Springfield House, Springfield Close R/230/19/PL

I am writing to express my concern at this application to substitute a triple garage with living accommodation over for the permitted single storey double garage.

Job Title	Springfield House		
Client	Castle Property Developments		
Drawing Name	Garage - Plan & Elevations		
Drawing Status	Planning		
Drawn by	DF	Date	Sept 19
Checked by		Date	
Drawing Scale	1:50 & 1:100 at A1		
Drawing No	Status	Revision	
181303/	09

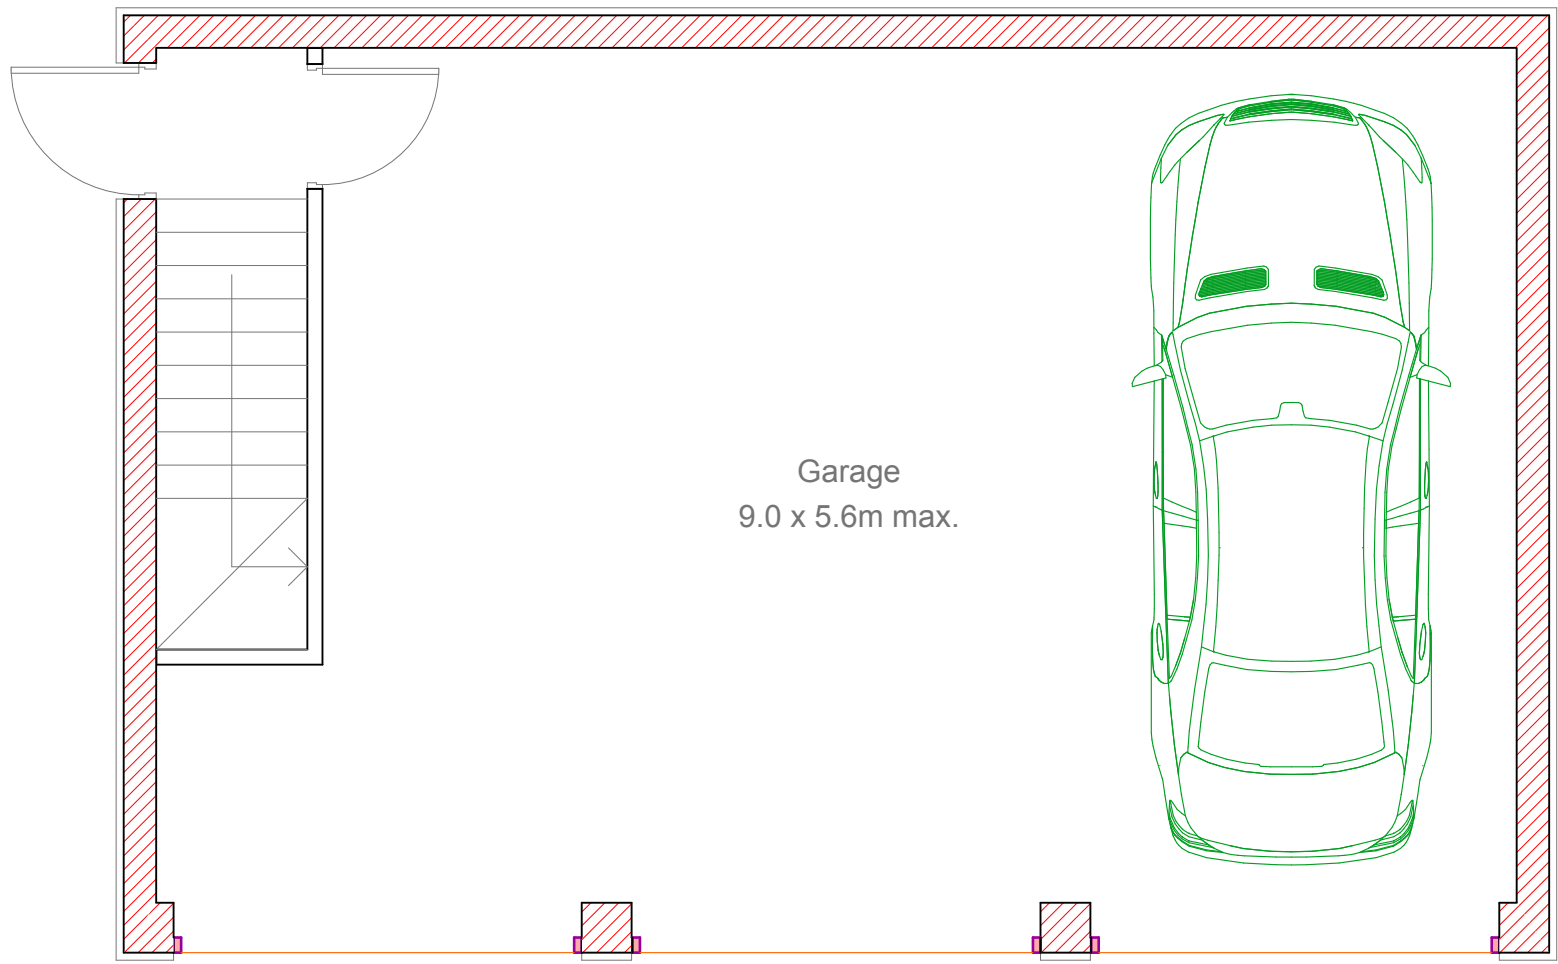
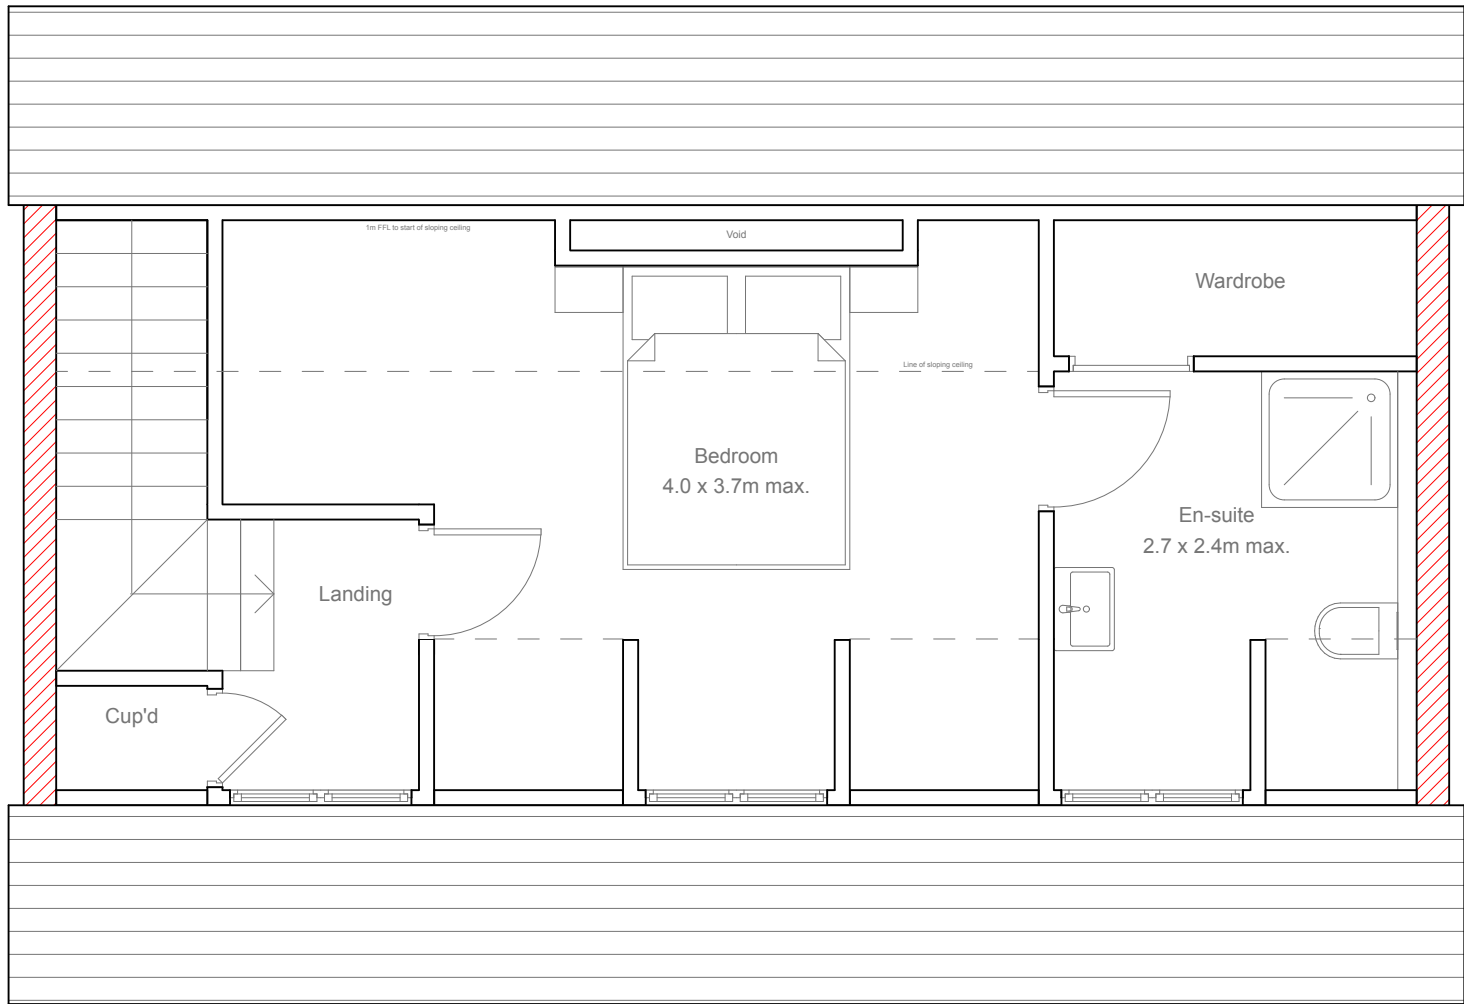
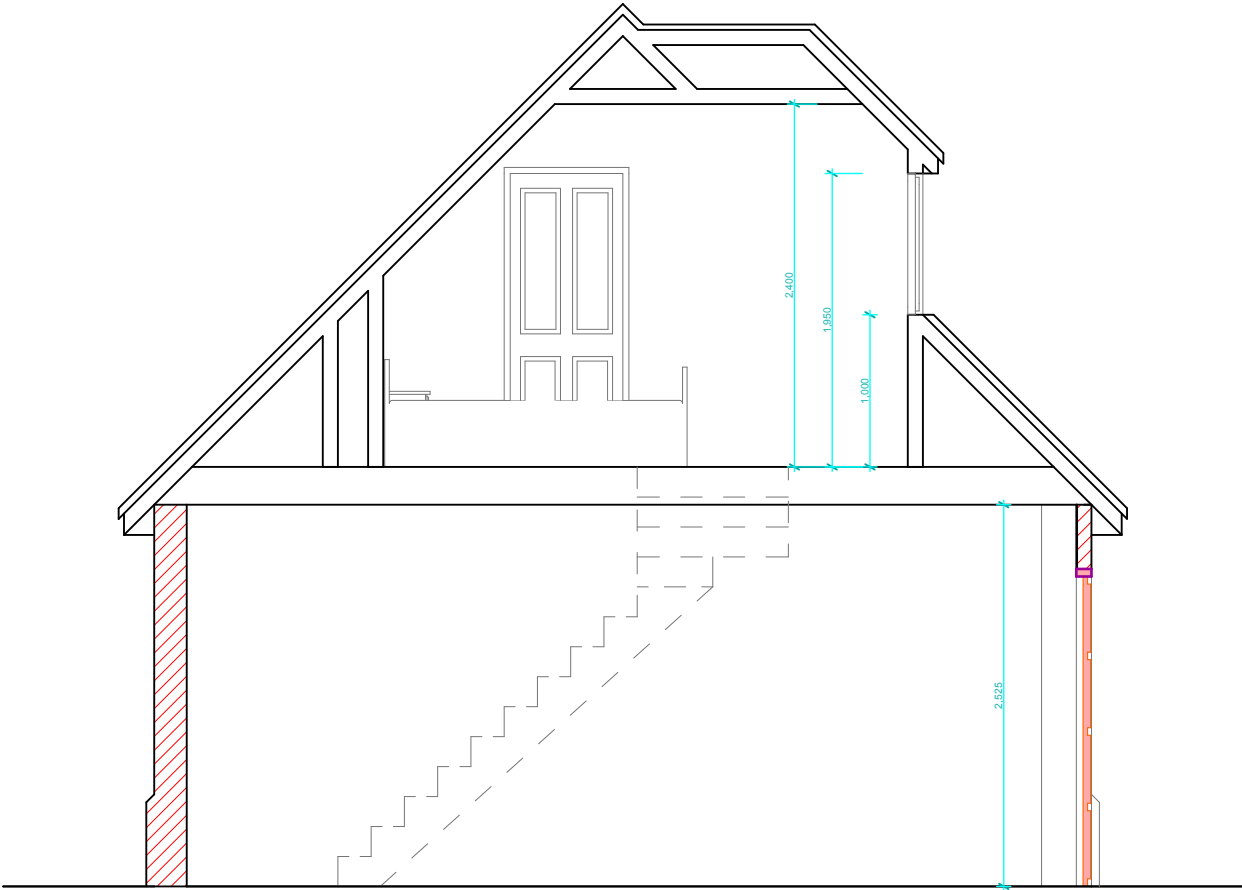
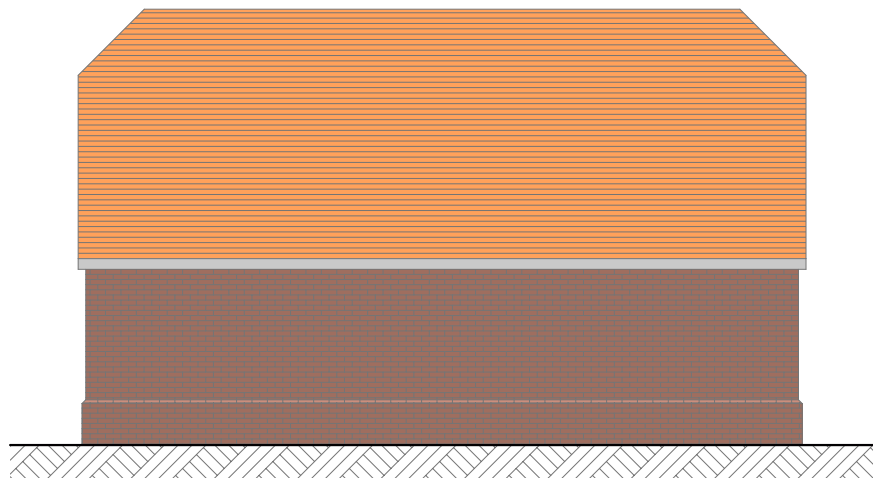
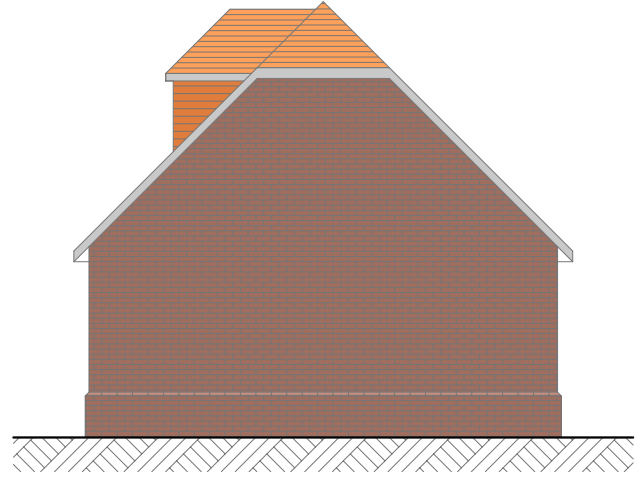
The permitted garage has been replaced by a totally different structure - in a tight corner position on the north east rear boundary with the Spire. It would have a detrimental effect on the Spire. Its windows would overlook its garden. My objections are (1) Overlooking and (2) Backfilling.

(1) Overlooking

I am aware that the Council takes seriously issues of overlooking when considering planning applications. See Little Deerswood, Horse Avenue, Kingston upon Hull K/4/19/PL where the Council refused permission for a replacement dwelling on the ground of its unacceptable impact on residential amenity contrary to Arun Local Plan Policy D DM1(3); Policy 7.1 (iv) Kingston Neighbourhood Plan.

(2) Backfilling

The proposed structure would amount to a backfilling of this garden site. As such, it should not be approved. This proposal is similar to the recent
